COUNTY COUNCIL'S RESPONSE TO CONSULTATION ON THE FOLLOWING DEVELOPMENT PROPOSAL

Application No: 17/02167/F

Proposal: Conversion of building from B1(a) Offices to 25 residential flats, with ancillary parking, bin storage and amenity area

Location: The Old Malthouse St Johns Road Banbury

Figure 27.0 – Proposed ground floor plan

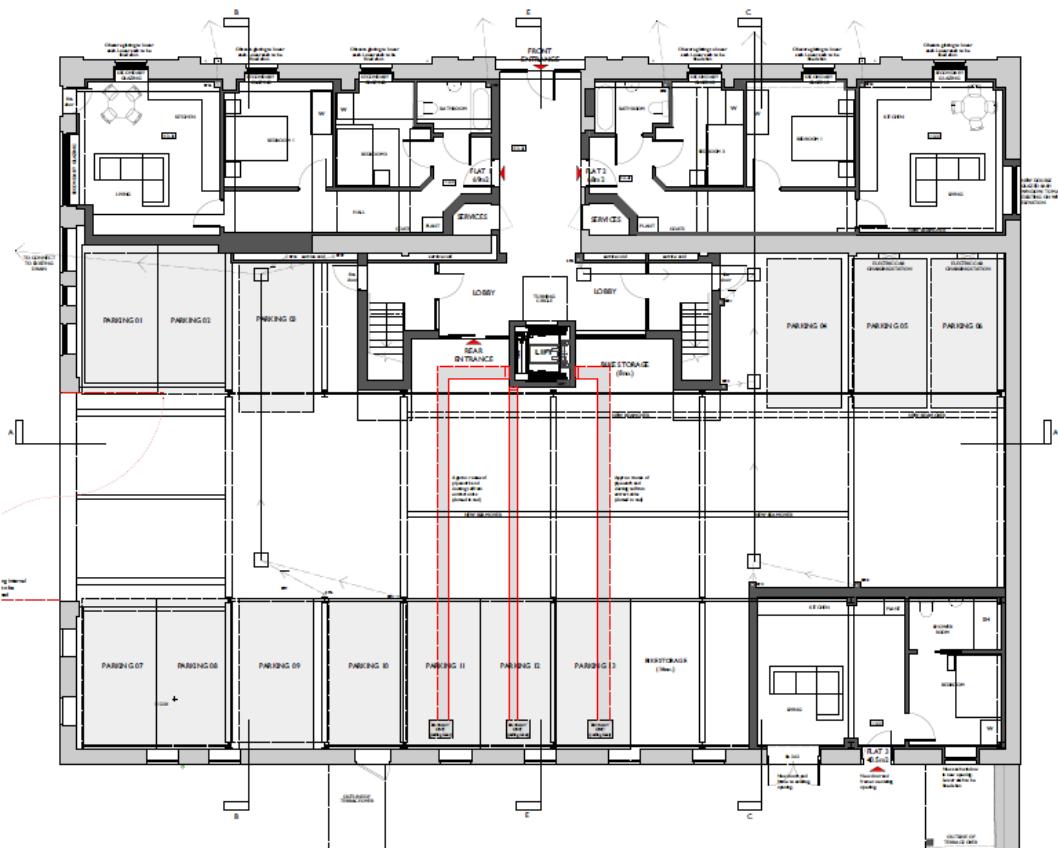
- The applicant has not shown on a plan where they intend to put the communal refuse store. This should be located within 5m of the edge of the carriageway on St. Johns Road so that refuse can be collected safely.

- Disabled access is from the rear entrance to the building located on the northern side of the under-croft car park on the ground floor of the building. However this is accessed through a pair of gates south of the highway boundary on St. Johns Road and from an access lane of approximately 4m in width and across the above mentioned car park. There is no marked out footway and no external lighting, and it is not clear how a pedestrian, a cyclist, or a wheelchair user would operate the access gates.

As stated in my response to the request for pre-application advice of 1 September 2017 (Ref: 17/00211/Pre-app), pedestrians and residents who might park their cars at the frontage of the building appear to be able to access the development via the proposed front entrance. Motorists who need to park in the under-croft area to the rear of the main building will need to travel through an access to the western side of the building that is currently gated. The access from St. Johns Road has a bell-mouth of 7m wide and there is a gap of 7m between the gates and the carriageway edge. This is sufficient to allow one vehicle to wait while the vehicle owner unlocks the gate. The applicant needs to describe how the gates will be operated.

The access road that will lead from the gates to the turning area into the under-croft car park is 4.4m wide. This is not of sufficient width to allow the Local Highway Authority to adopt the access road. The applicant will also need to mark out an over runnable area for pedestrians, cyclists, and disabled users, both along the access road and through the western part of the under-croft car park to the rear entrance to the building and the cycle storage areas. This area should also be lit. The applicant should also consider providing a ramp to the main access so that disabled users can access the building without having to go through the car park.

The drawings provided with the application differ from those submitted with the request for pre-application advice in August 2017. For example, Drawing No. 17_057 201C that has been submitted with this application does not display the whole curtilage of the site, although the applicant states in the Design and Access Statement that refuse collection facilities will be provided. These are not shown on this drawing. I stated in my response to the request for pre-application advice on 1 September 2017 that, due to the number of flats, and that a communal refuse collection area will need to be provided, the refuse collection area will need to be located in an area where a refuse collection vehicle can get within 5m of it. I do not see any proposed refuse collection facilities on the plans provided. Therefore, I have to object on these grounds.

The applicant has stated that they will be able to provide up to 22 vehicular parking spaces within the curtilage of the site. From Drawing No. 17_057 201C it appears that they intend to provide 13 spaces in the under-croft area on the ground floor of the building. I assume that the other 9 spaces will be the existing ones that are immediately north of the existing front entrance to the building. Although these 9 spaces were shown on the plan that accompanied the request for pre-application advice, they are not included in the plans submitted with this planning application. The applicant will need to confirm that they still have control of this area of the curtilage of the building. However, I would question whether all of these 9 spaces

could be provided because of the need to provide a refuse collection area within 5m of the highway boundary on St. Johns Road and a ramp to the main entrance.

Prior to the commencement of development, a plan showing the location of refuse collection facilities for the development must be submitted and approved in writing by the Local Planning Authority. Thereafter, and prior to the first occupation of the proposed development, construction shall only commence in accordance with the approved details.

Prior to the commencement of development, a plan showing how residents with disabilities will access the development must be submitted and approved in writing by the Local Planning Authority. Thereafter, and prior to the first occupation of the proposed development, construction shall only commence in accordance with the approved details.

Prior to the commencement of development, a plan showing all internal vehicular parking spaces which will be part of the development must be submitted and approved in writing by the Local Planning Authority. Thereafter, and prior to the first occupation of the proposed development, construction shall only commence in accordance with the approved details.
